Tel: 01903 737756
Email: planning@arun.gov.uk
www.arun.gov.uk/planning
Please ask for: Laura Mills
Email: laura.mills@arun.gov.uk
Telephone: 01903737794
Our Ref: BR/171/26/PL
Your Ref:
Date: 29th September 2026

Application for Planning Permission

Development: Proposed single storey flat roof extension to the rear of exsisting AGC, including installation of external associated a/c plant and smoking shelter to existing yard area.

Location: 32 London Road Bognor Regis PO21 1PY

Rear North Elevation as Proposed
Scale 1:50

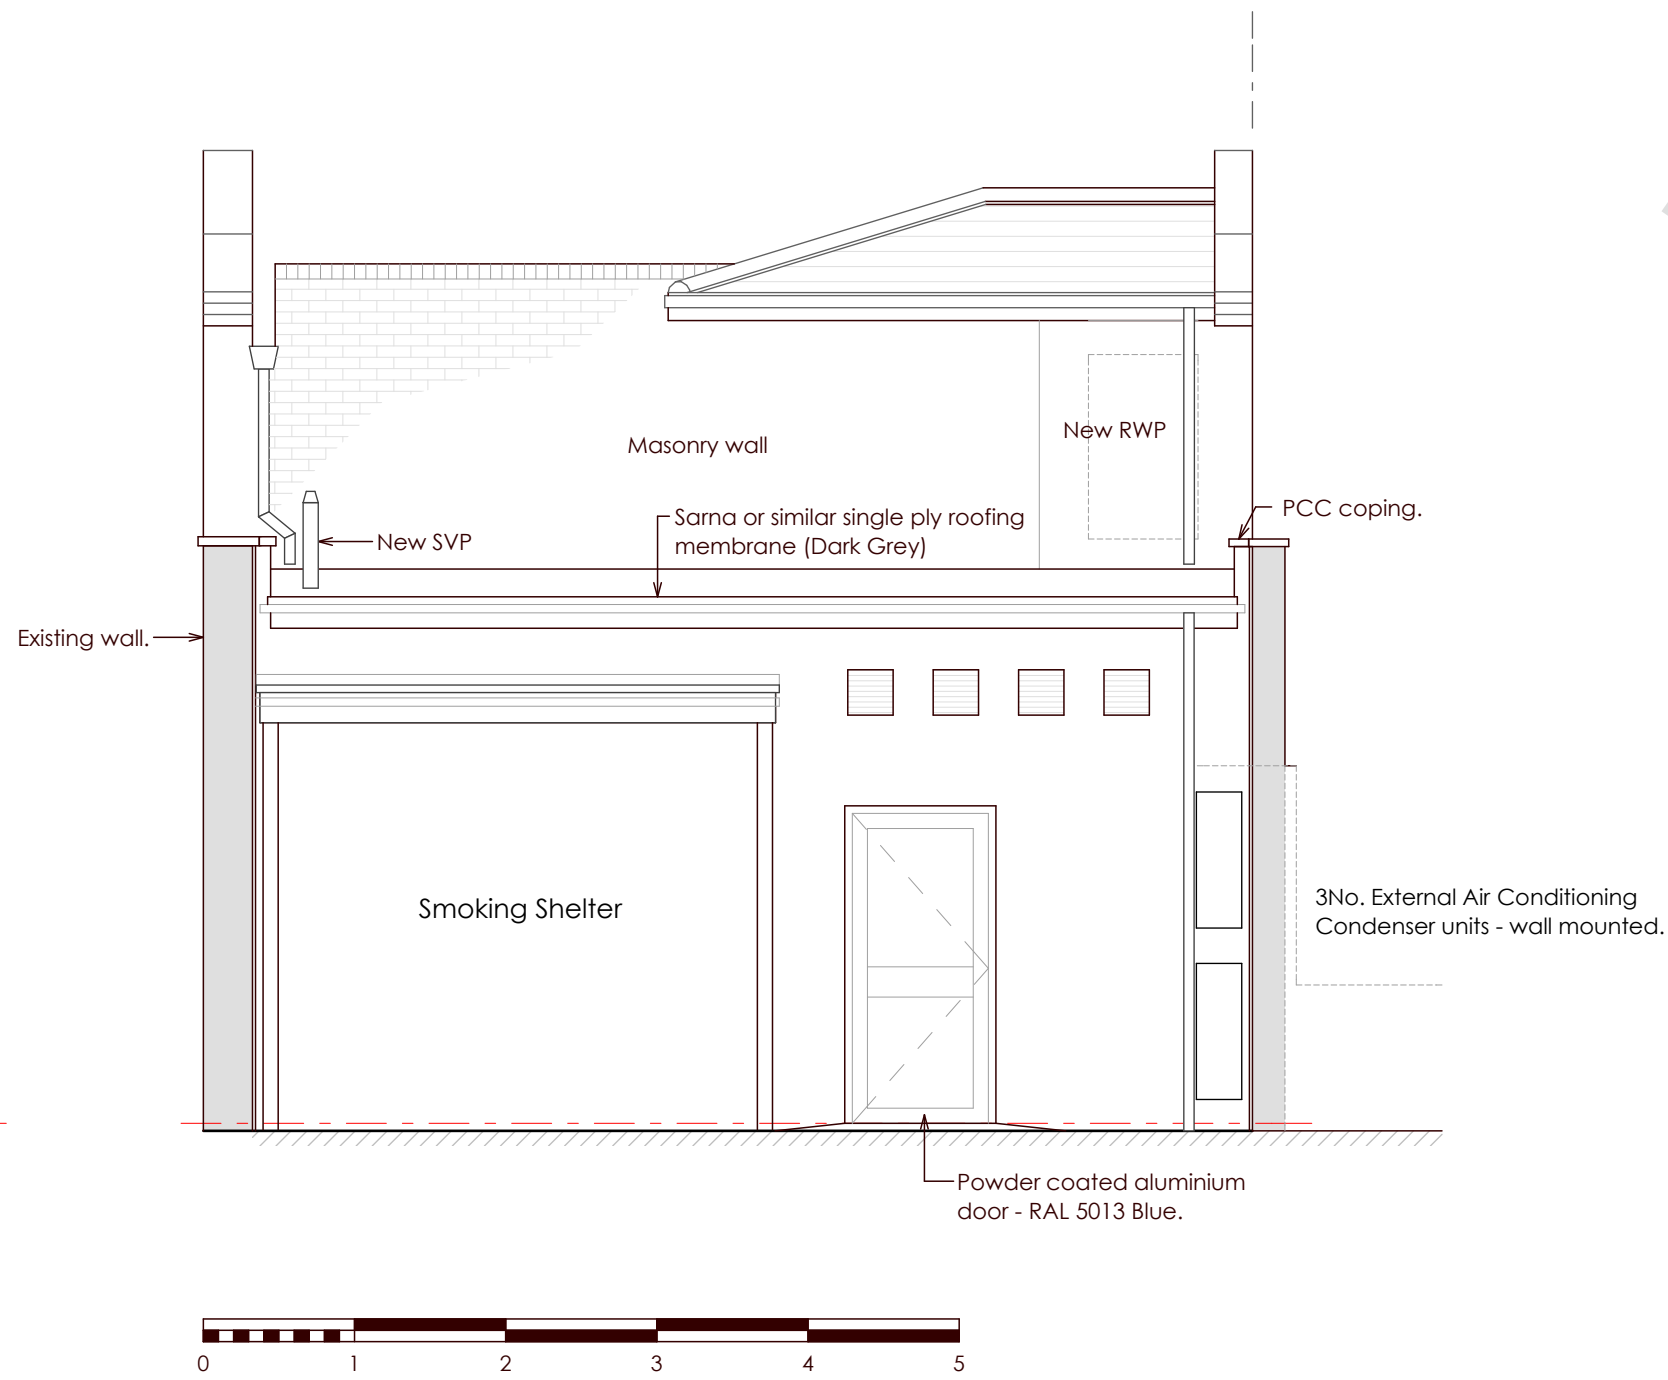
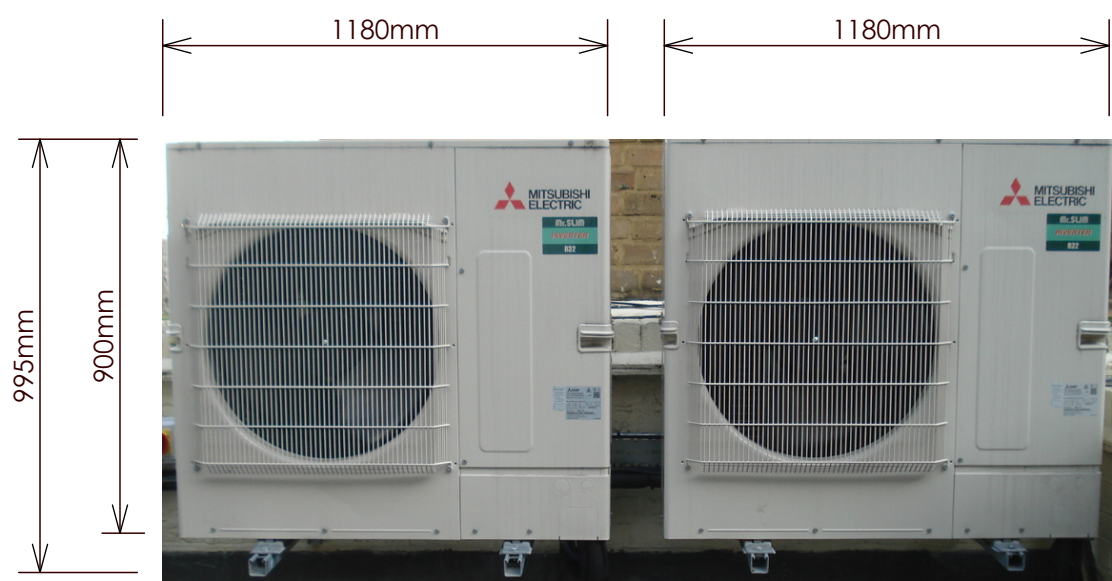
Proposed Elevations Sheet no. 3635(C)02

There appear to be 2 x 'West' labels, please amend to show 'East' and 'West'

The condensing units are not scaling at 1:50 please amend to show correct scale.
